I wish to submit the following supplementary comment in relation to application 2026/91484.

Layouts for proposed pair of dwellings  
to replace plot 27.

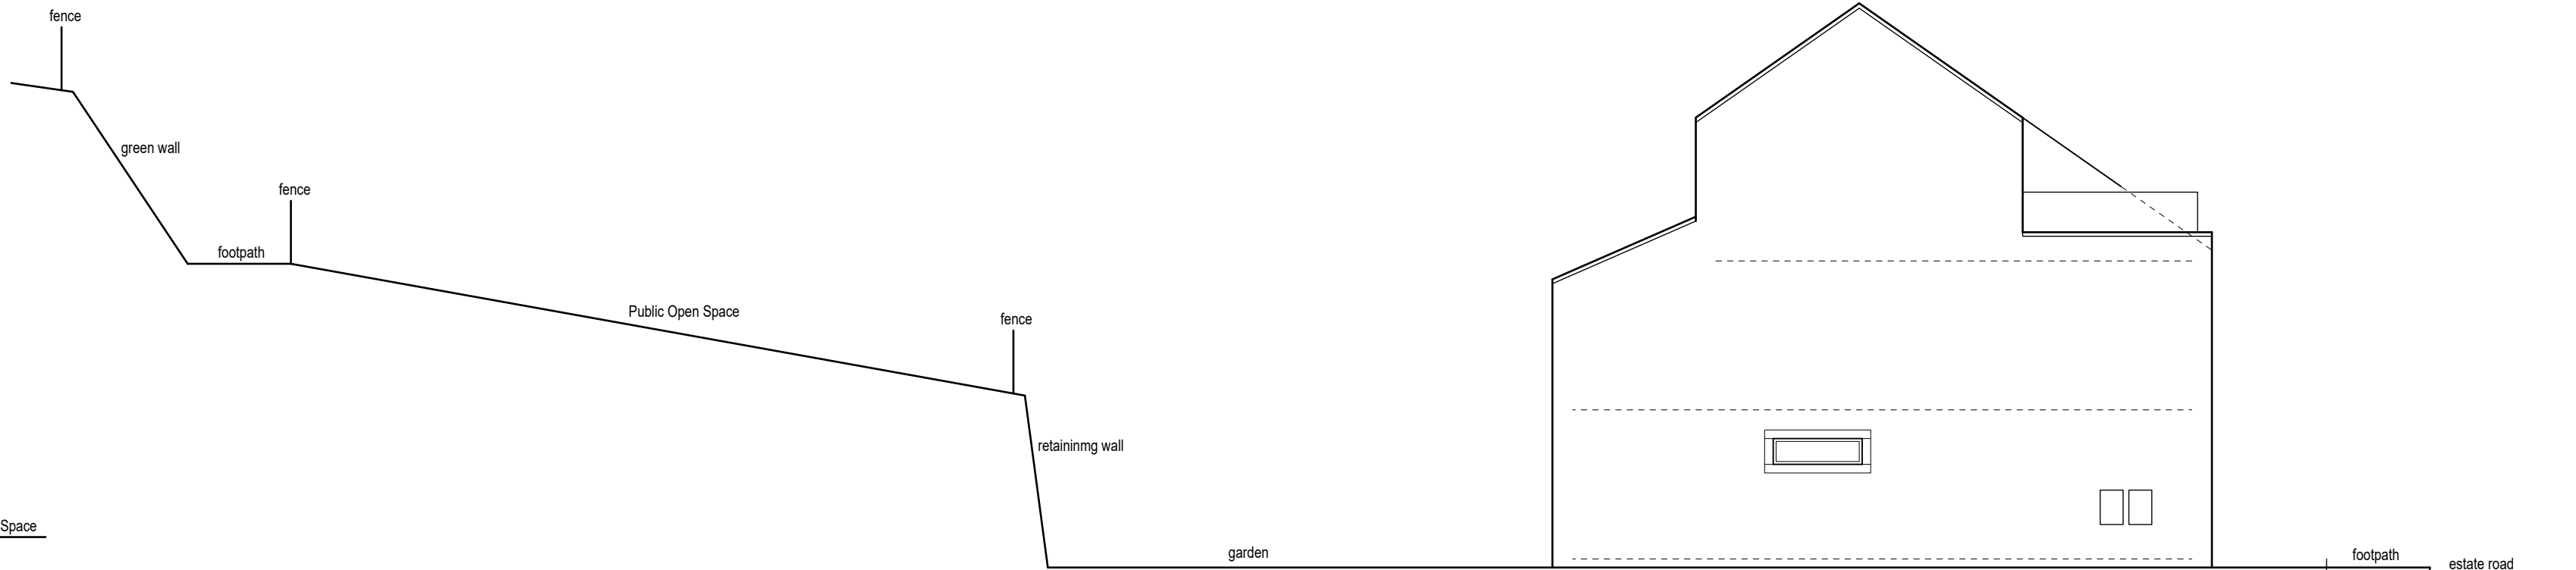
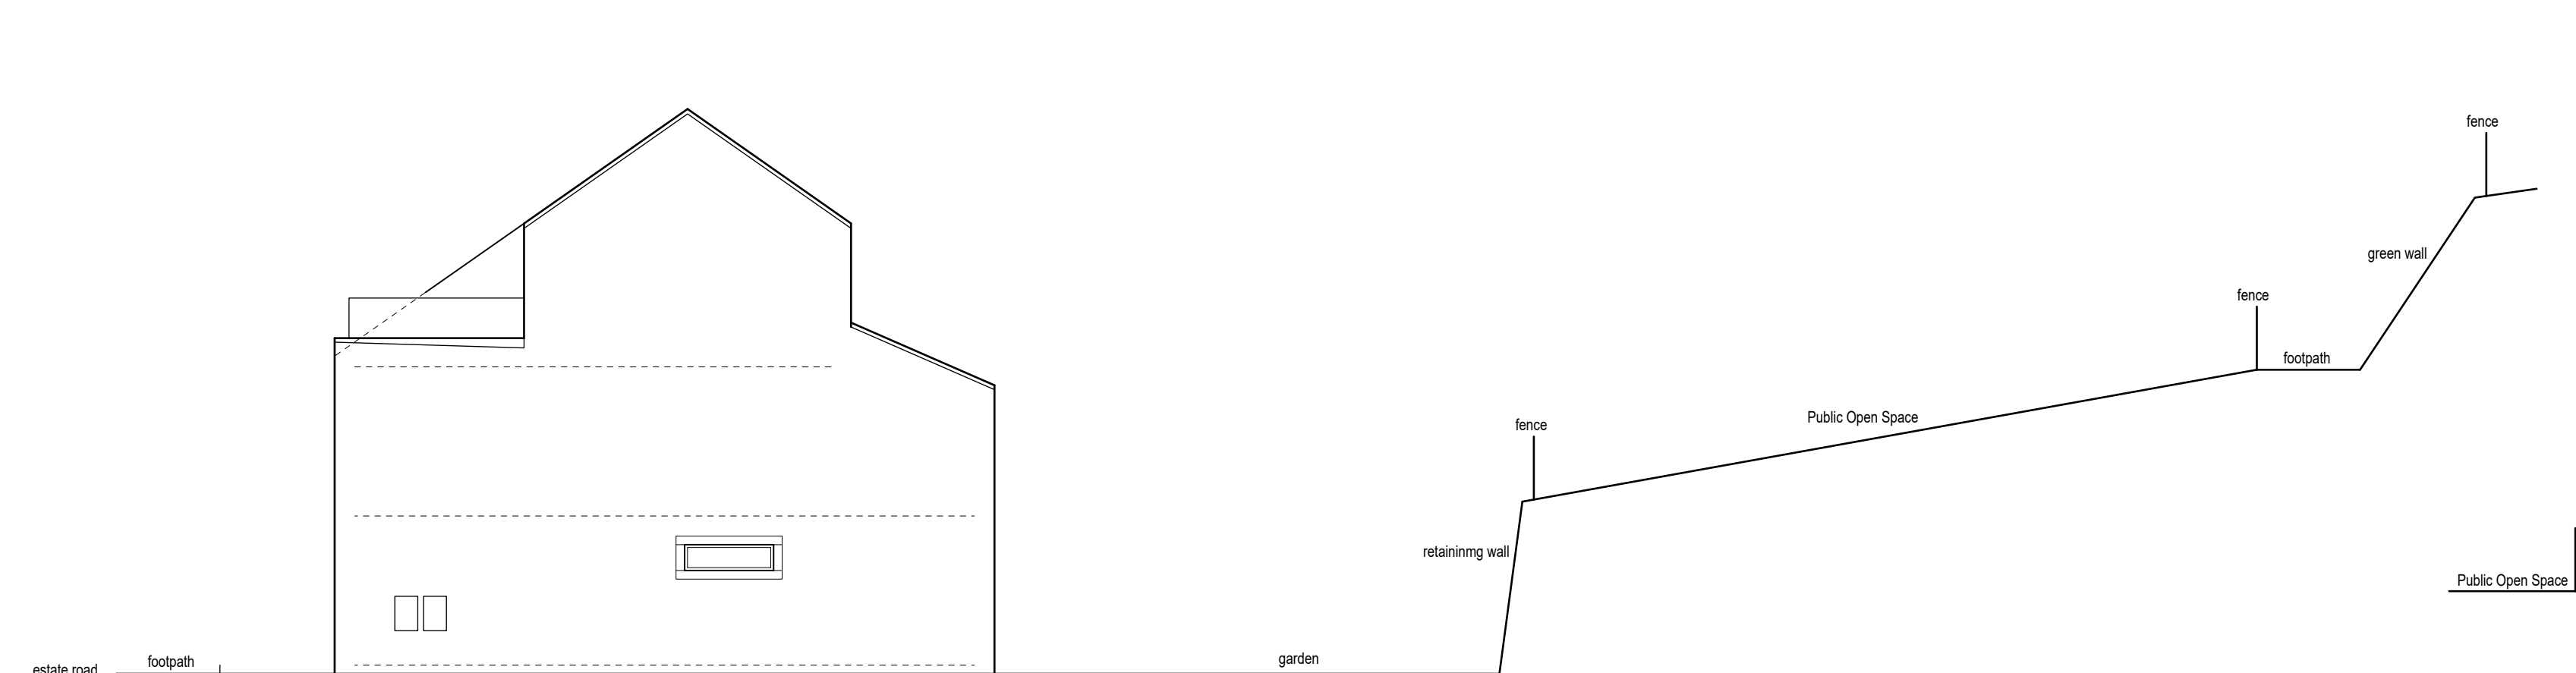
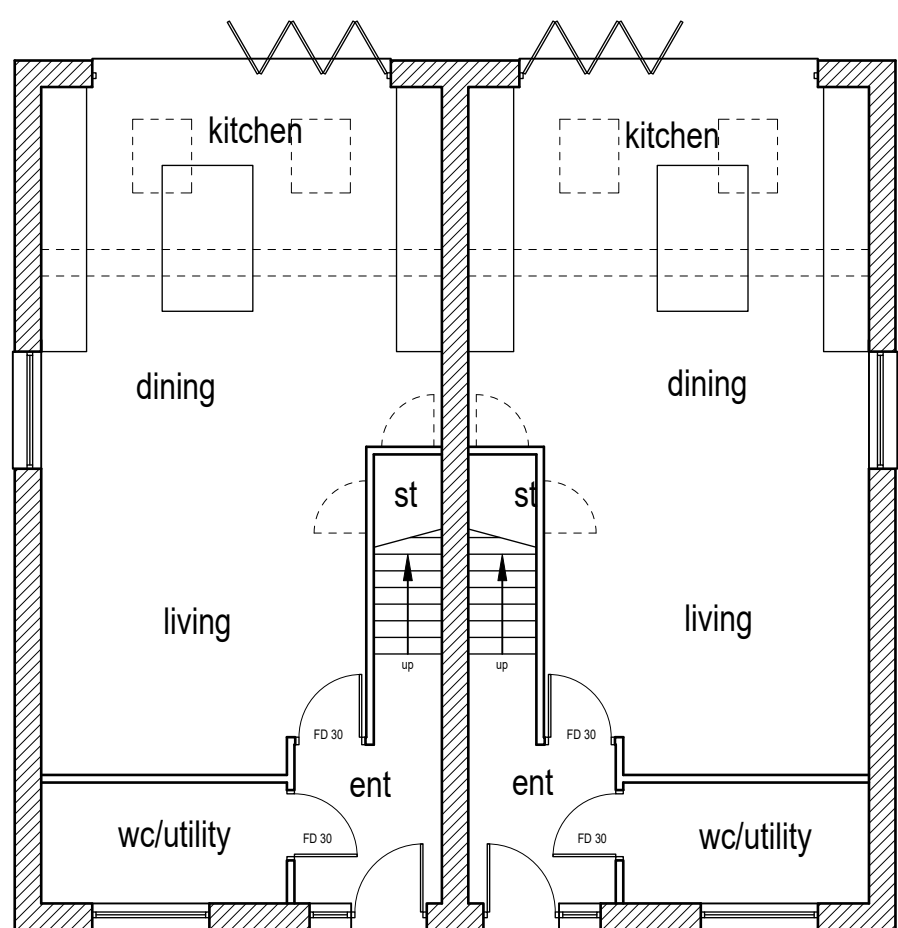
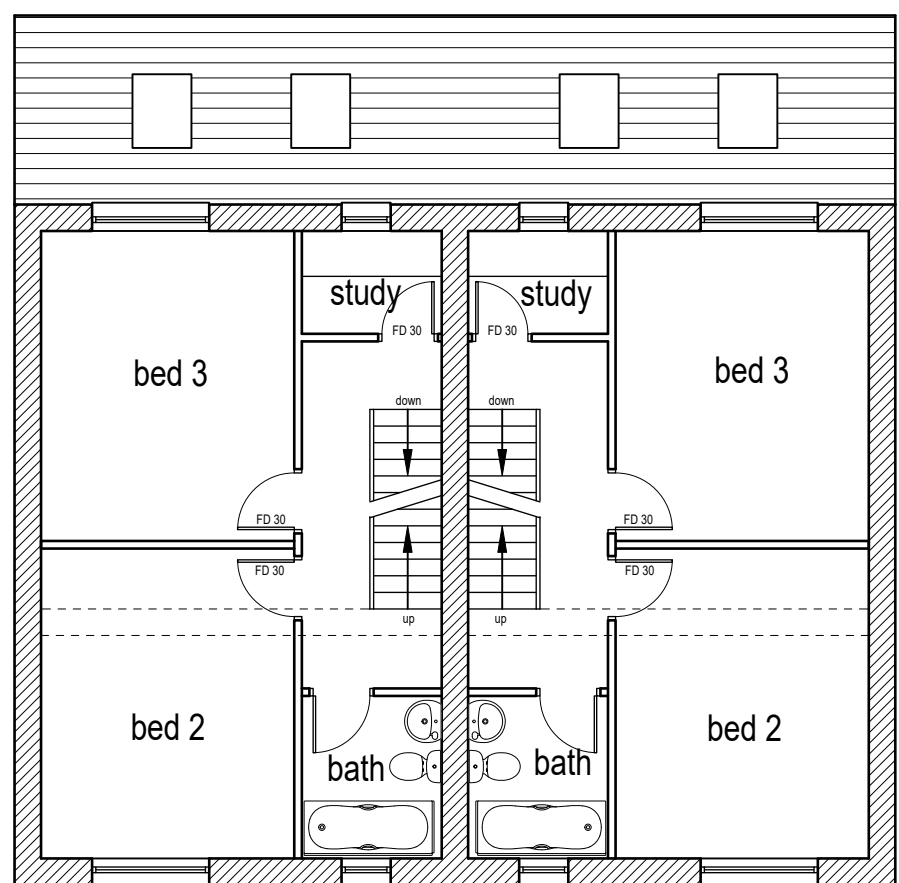
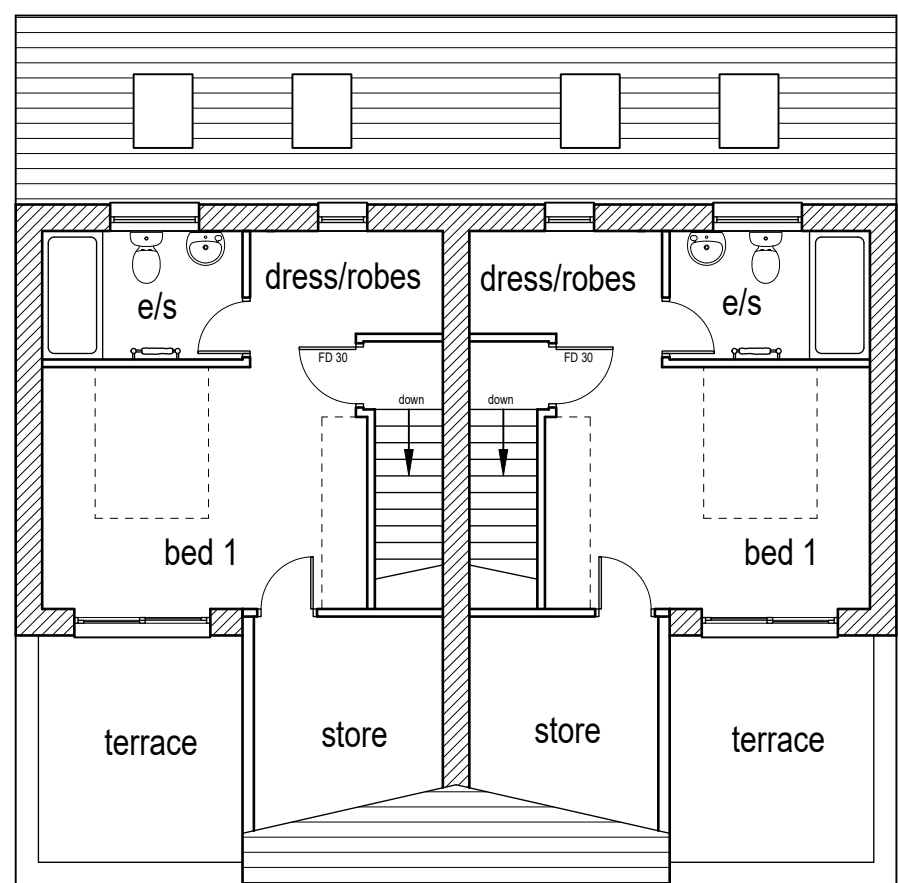
The current proposal fundamentally changes that concept. The pedestrian pathway has been removed entirely and the introduction of plots 27 and 27a changes the relationship between the retained trees and the surrounding public space. The remaining POS becomes a differently configured landscape rather than the integrated public amenity that was previously approved.
